**From:** Sarah Burrow <Sarah.Burrow@arun.gov.uk>  
**Sent:** 18 May 2022 13:25  
**To:** Obafemi Okusipe <Obafemi.Okusipe@arun.gov.uk>  
**Cc:** Planning.Responses <Planning.Responses@arun.gov.uk>  
**Subject:** RE: Planning Consultation on: CM/16/22/DOC

As I had stated that I would happily recommend discharge of the conditions if the relevant information was provided I will do so. Please discharge condition 10 imposed under CM/16/22/DOC.

Title DRAINAGE LAYOUT

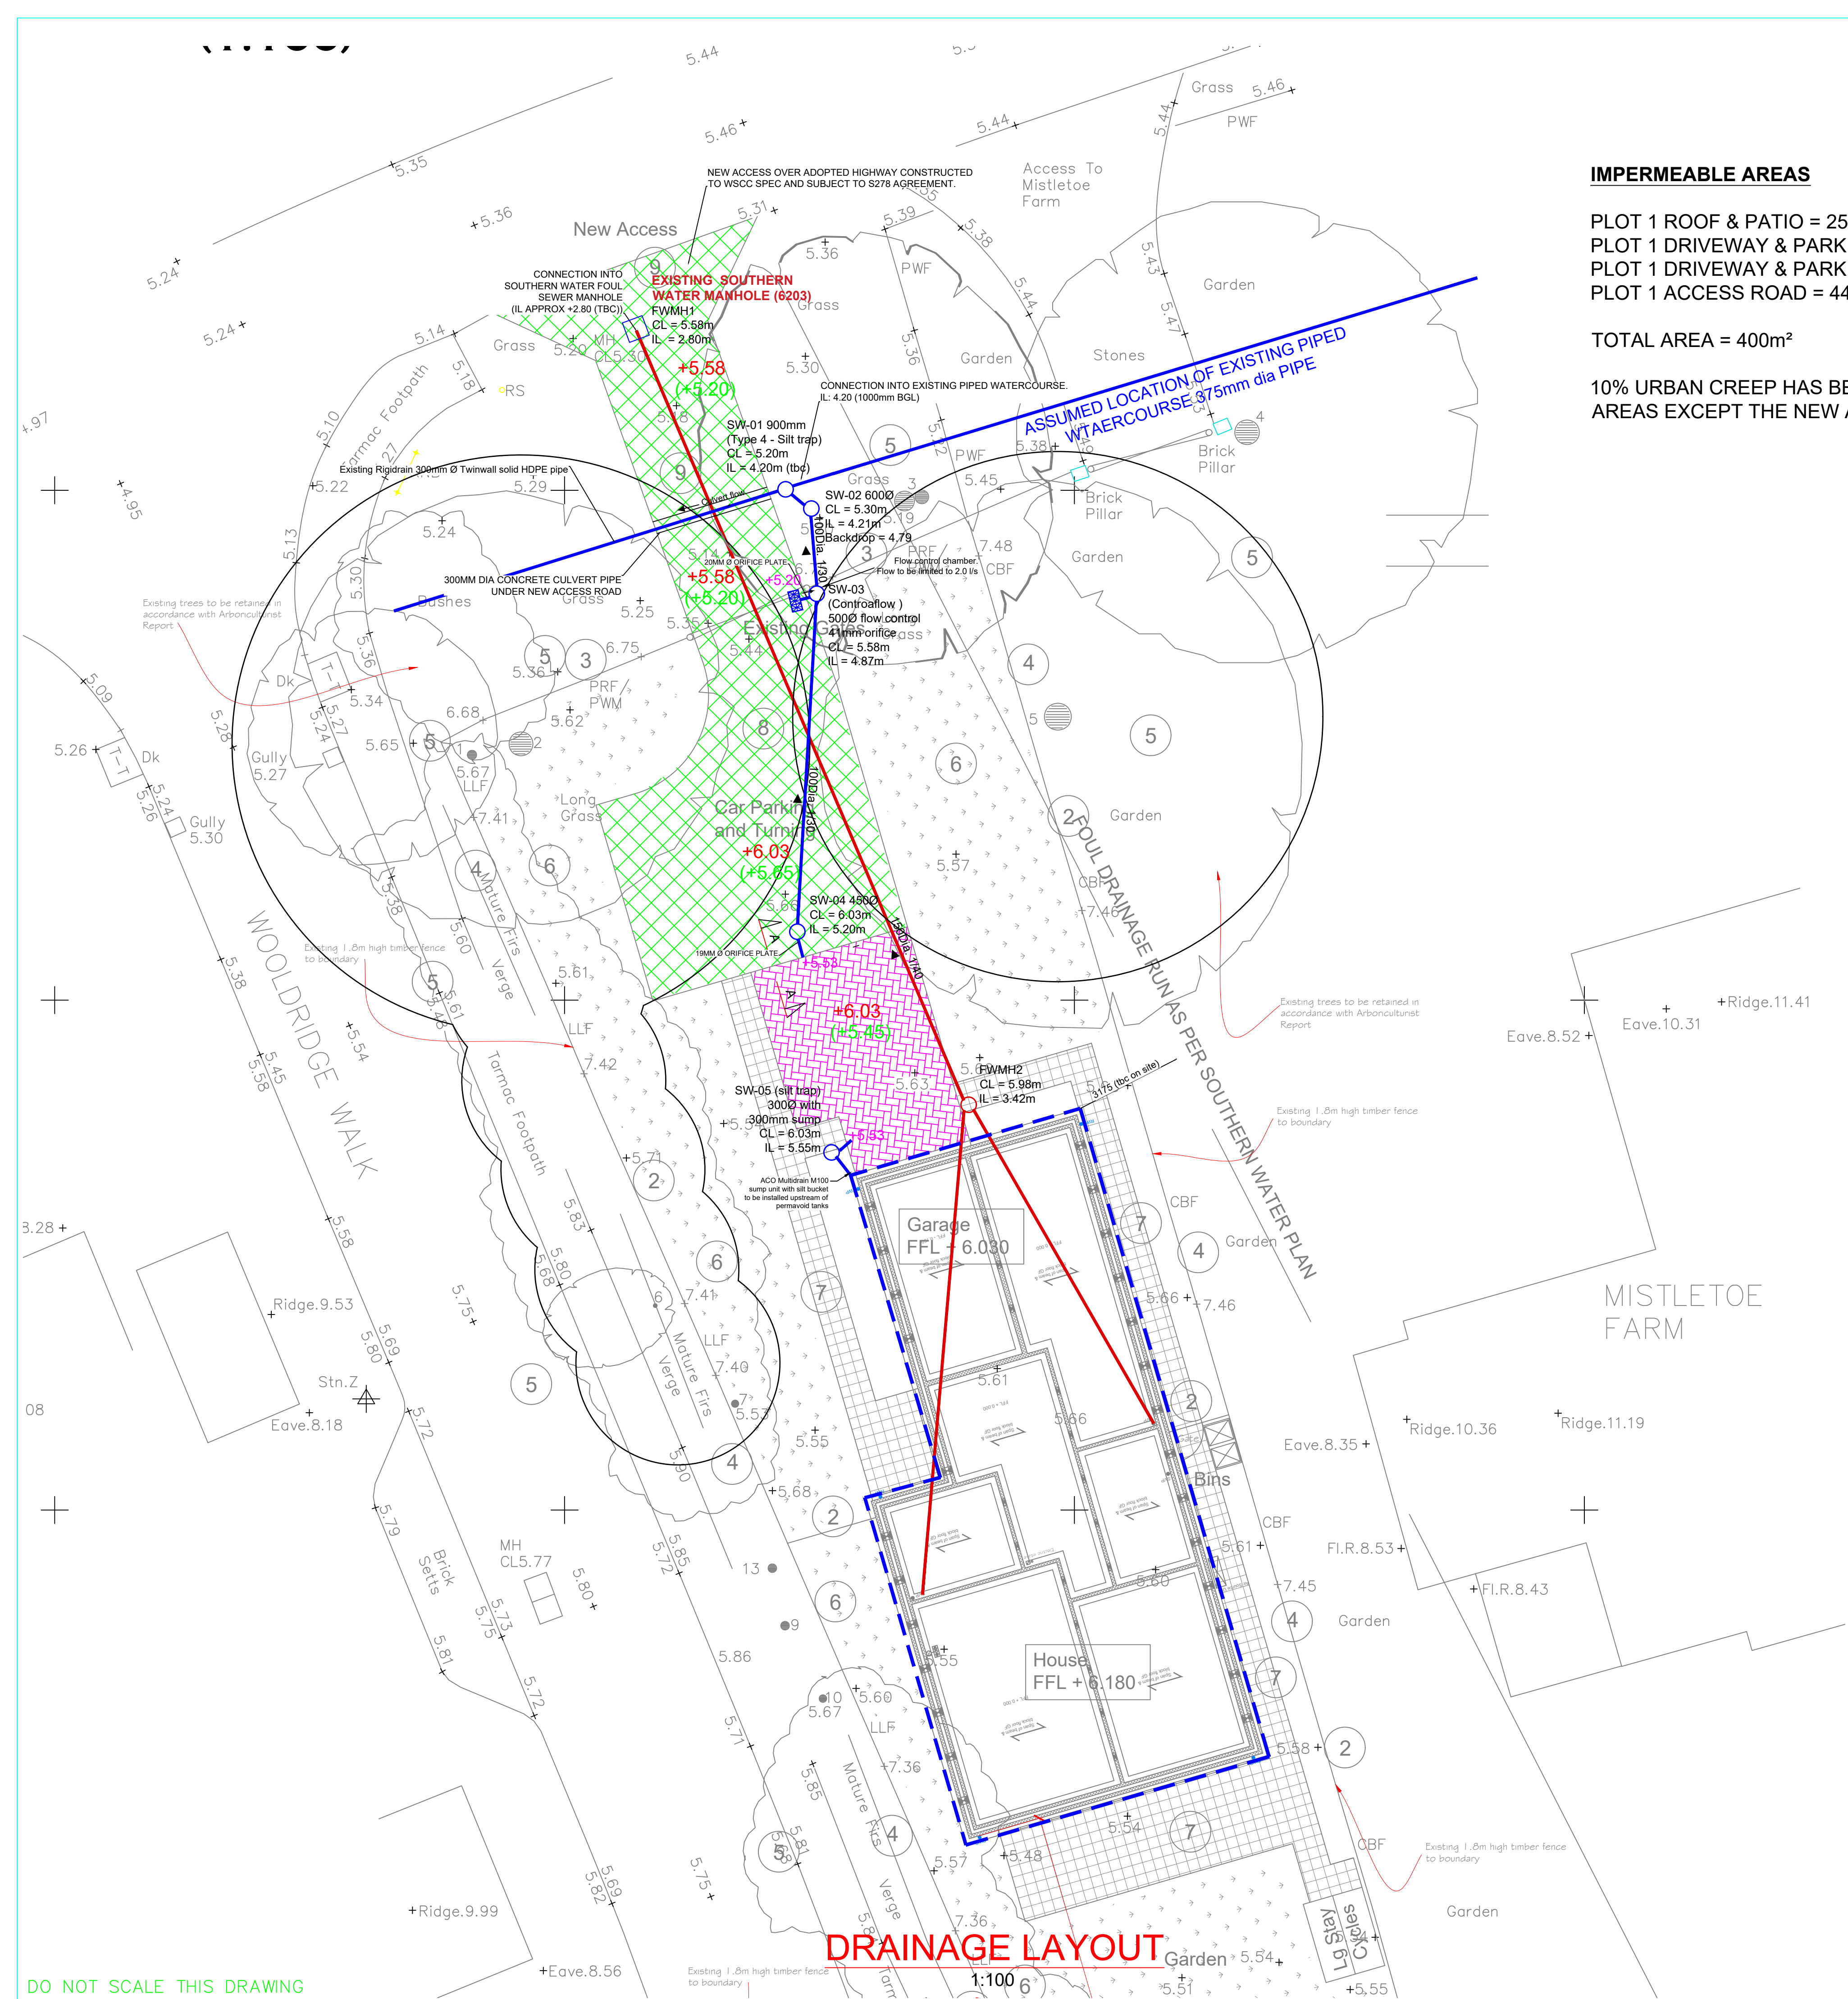
However, the applicant still needs to get land drainage consent for this site and at present the discharge location is blocked downstream. There is a risk that the invert level of the culvert may not be correct, this will need to be proven with a trial hole as part of the land drainage consent process. If the invert level is not correct then a new DOC application will need to be made with adjusted levels.

Should a new DOC be necessary then I would expect all connections to be shown soffit to soffit. I do not feel it is fair to request this adjustment now on the day of the deadline, however, if it is found that other changes and a new DOC are required then I would expect this to be changed on the plans too.

500MM Ø CONTROFLOW FLOW CONTROL CHAMBER DETAIL
SCALE 1:15

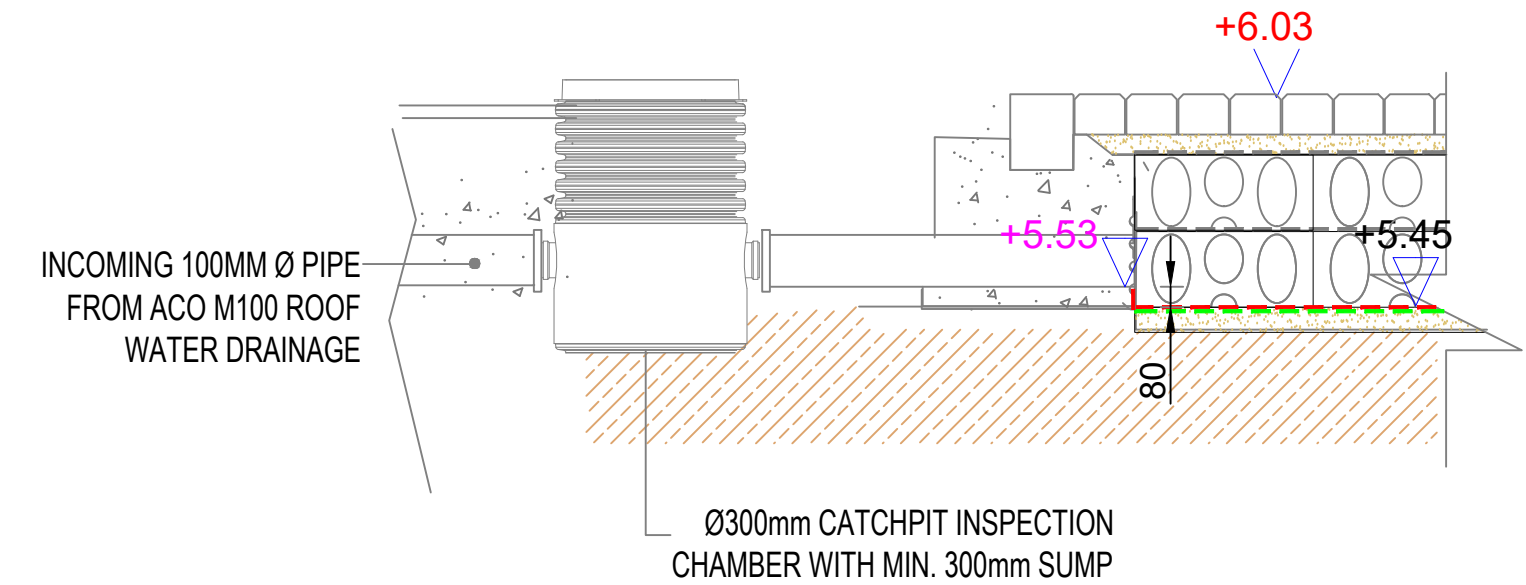
"I have followed up on Laura Gibbon's last consultation on CM/72/21/DOC. The only outstanding point that I can see relates to the Controflow flow control with orifice. Please can the applicant provide the previously requested

Former point 11: Please provide Controflow data to evidence orifice size and level are suitable.”
